BCA Assessment Report

St Aloysius College, Rozelle

Project: St Aloysius College, Rozelle
Reference No: 113752-BCA-r2
Date: 4 March 2022
Client: PMDL Architecture & Design Pty Ltd
Client Contact: Andrew Pender
Email: apender@pmdl.com.au
BCA Logic Contact: Ben Long
Direct: 8484 4009
Email: blong@bcalogic.com.au

48 Victoria Rd-Proposed Plan L1 St Aloysius College-Rozelle Campus

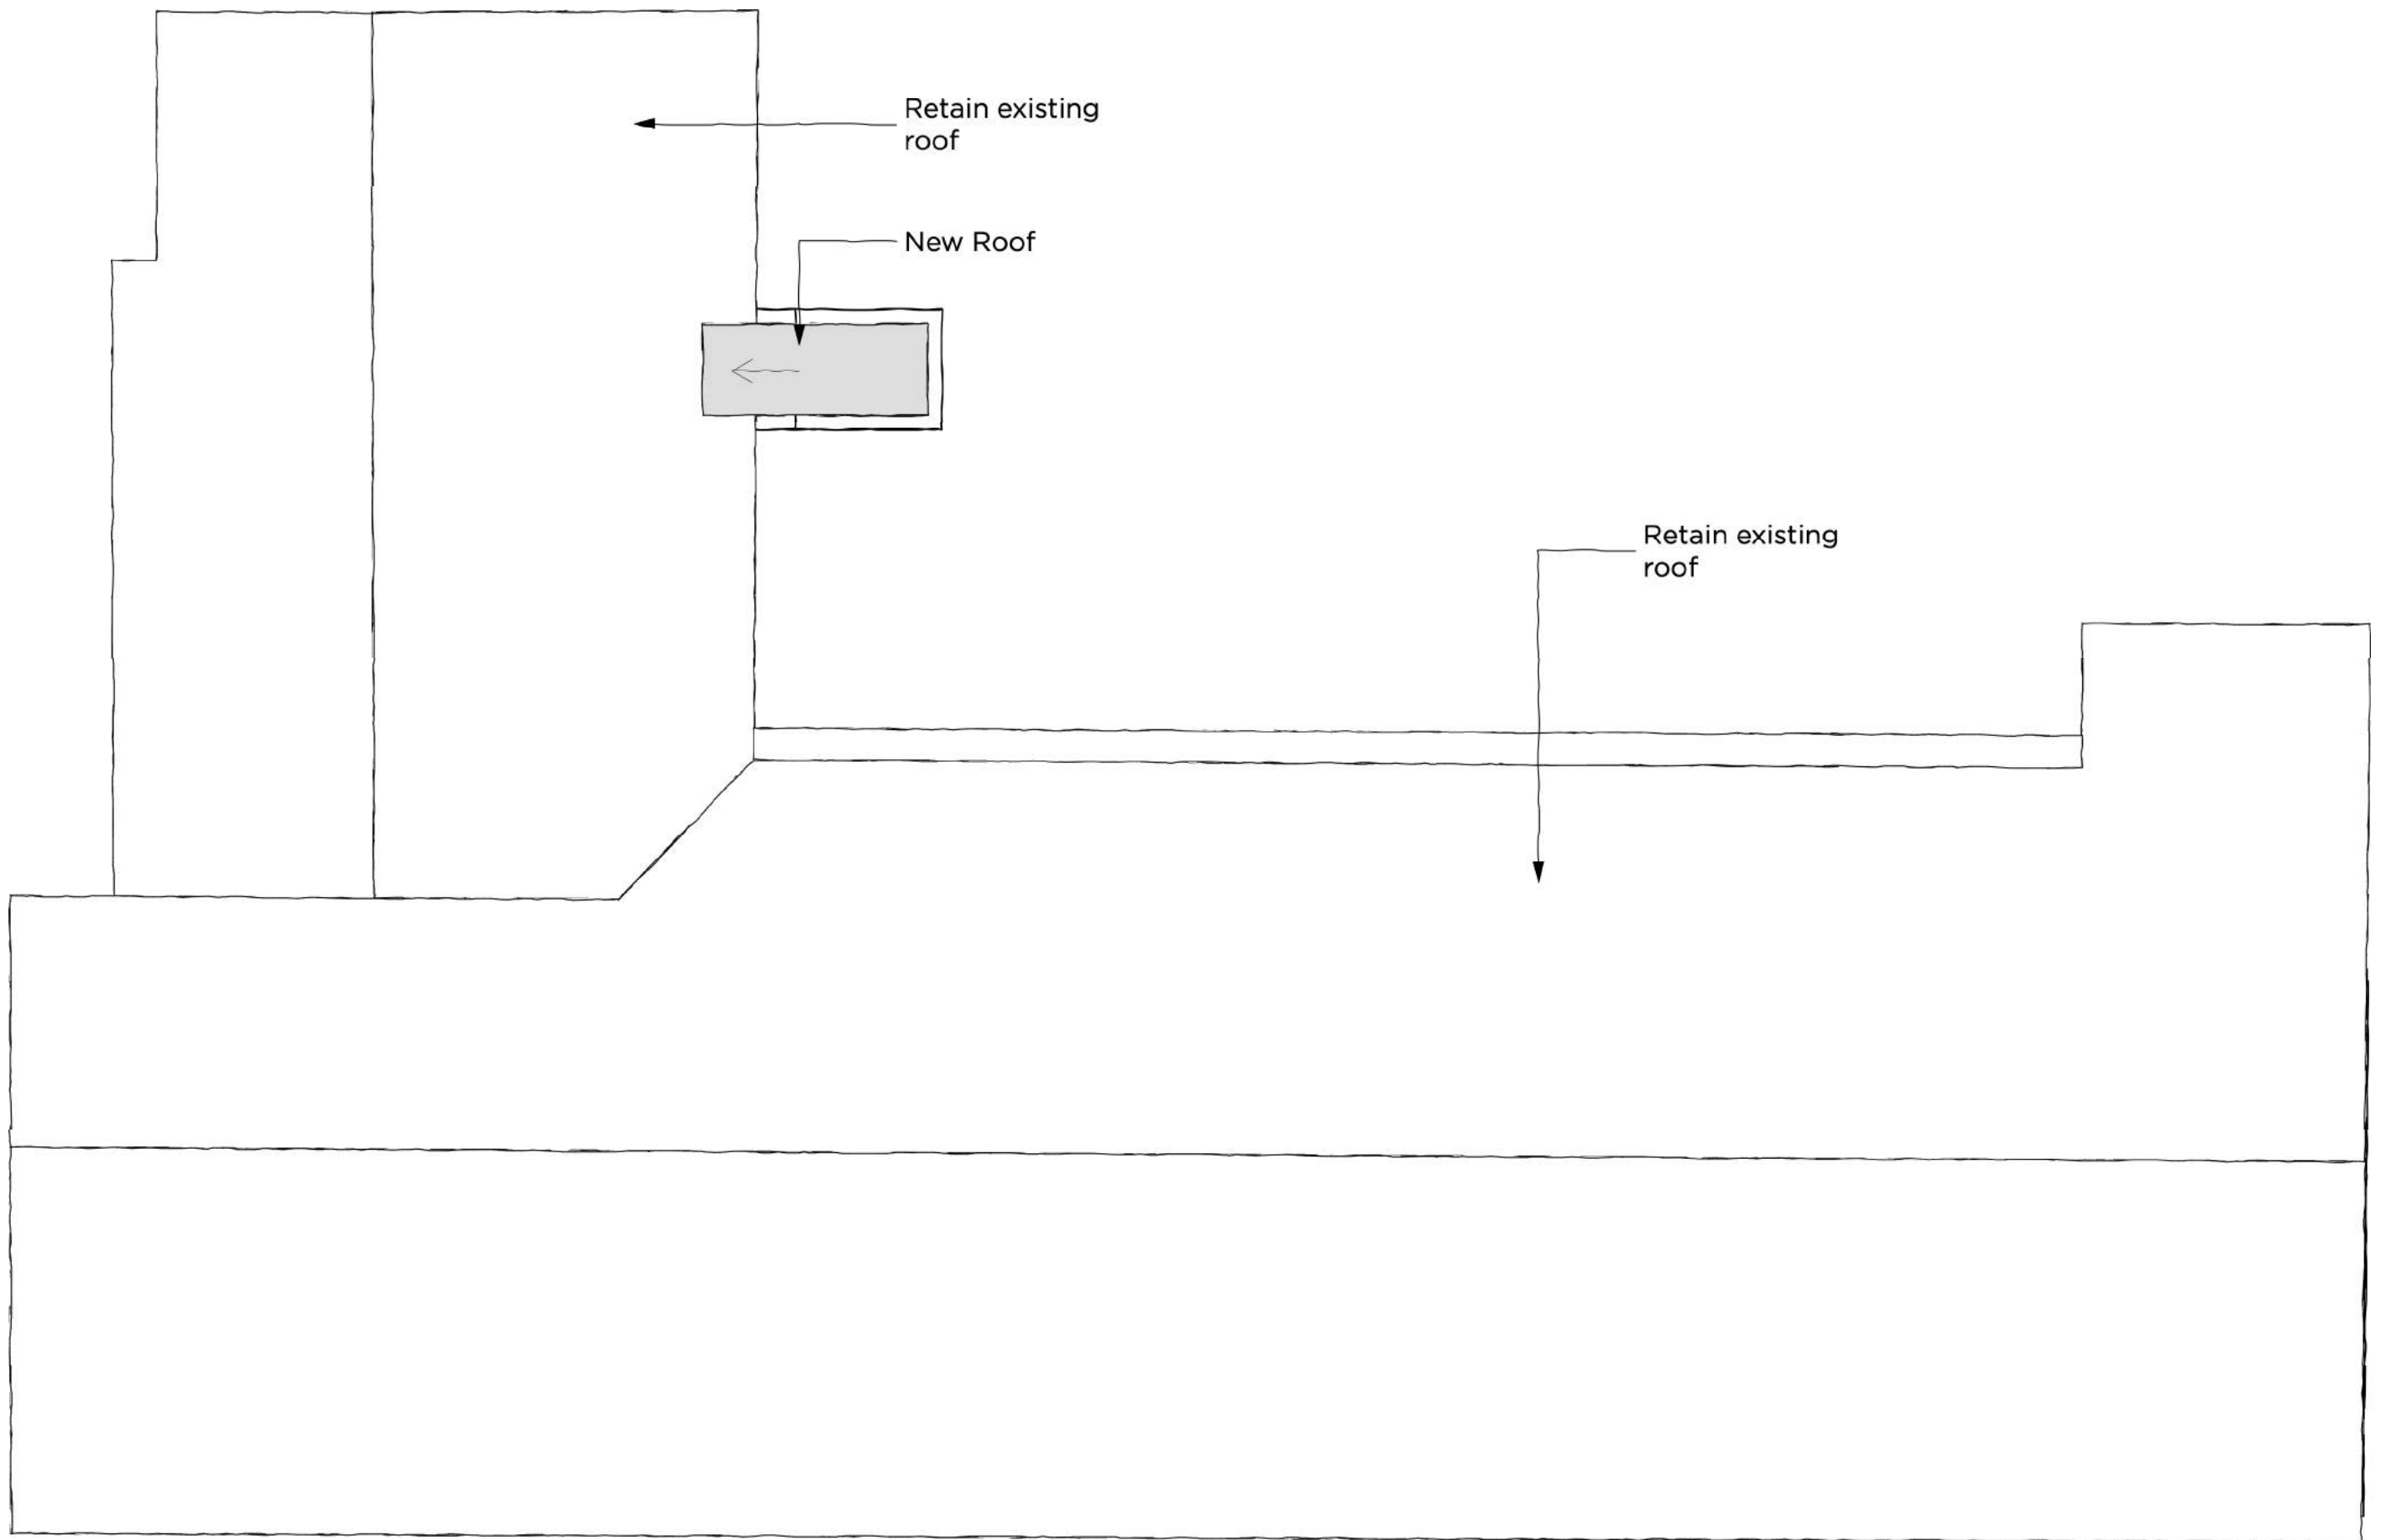
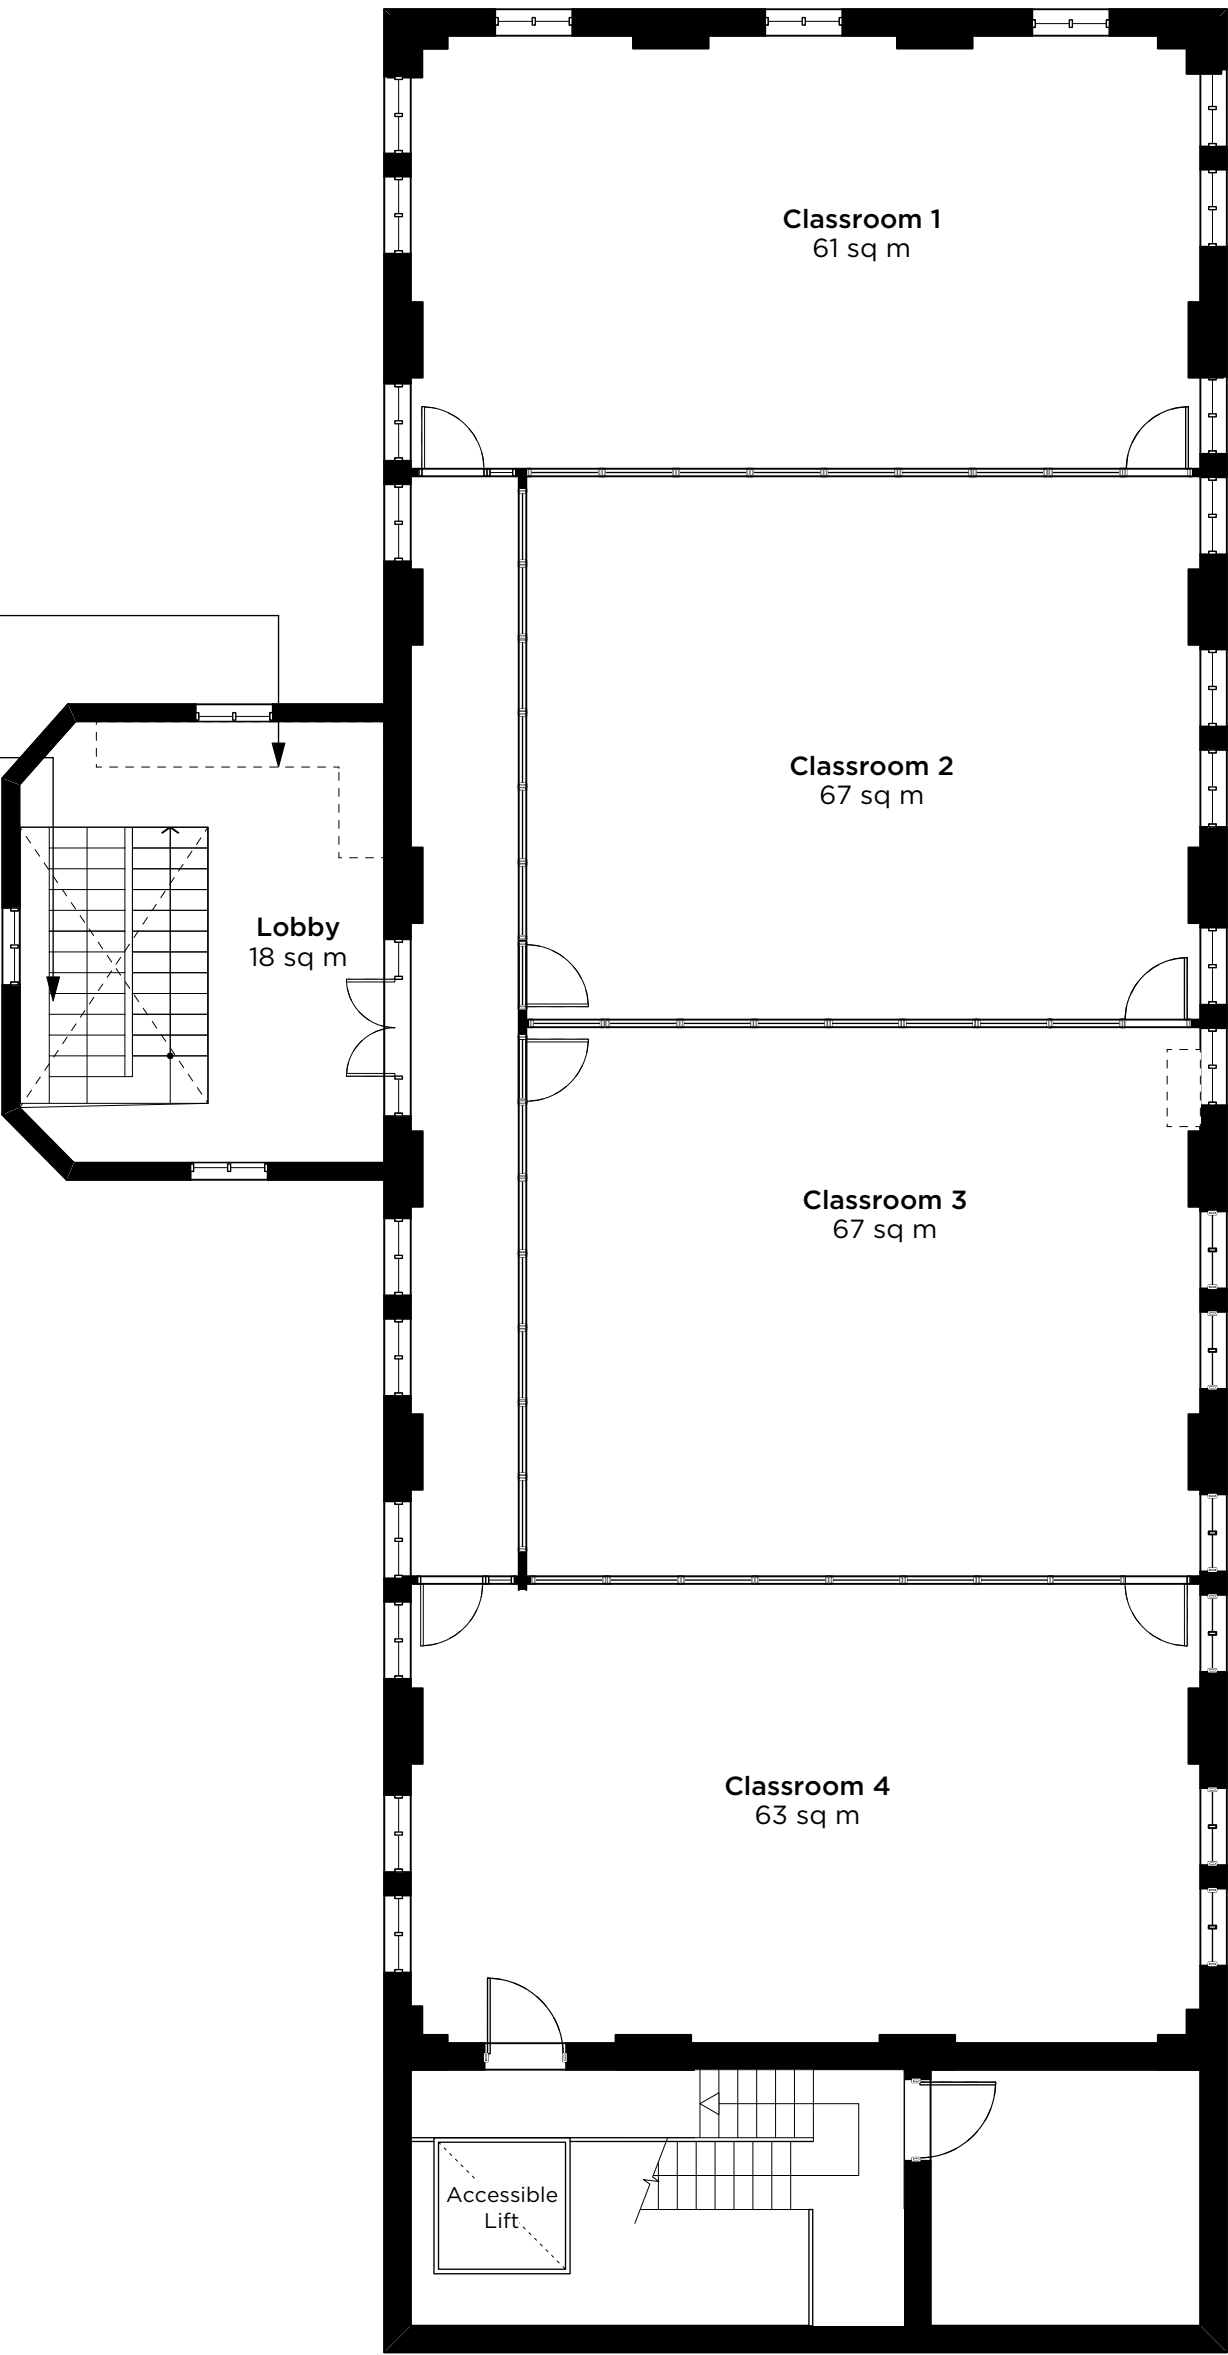
Furthermore, at the top of the western stair it is noted that there is an electrical board that will reduce the clear width to less than 1000mm. It would be required that this board is relocated as part of the new works to ensure that it does not impact on the egress widths.

Additionally, with the required works to the handrails under Clauses D2.17 and D3.3 it is considered that there will be a point on the western stair where the clearance between the handrails will be less than 1000mm and may need to be addressed via a Performance Solution – Refer to separate Access Report for more details.

Each of the non-fire isolated stairways are found to have an existing cupboard provided underneath that would not maintain the required FRL in accordance with this Clause.

It is noted that there existing barriers provided to the landing of the stairways are less than 1000mm and would not comply with this Clause. Additionally, the gaps provided within the barriers to the handrails would exceed 125mm and would not comply.

It is noted that there existing handrails provided to the landing of the stairways are less than 865mm and would not comply with this Clause. The handrails throughout will need to be replaced to ensure compliance is maintained in accordance with this Clause.

Furthermore, it is noted that the existing stair configurations did not provide an offset riser and therefore it would not be possible to maintain a consistent height throughout in accordance with Clause 12 of AS1428.1-2009. It would be possible to seek a Performance Solution to omit this requirement.

The barriers throughout will need to be replaced to ensure compliance is maintained in accordance with this Clause.
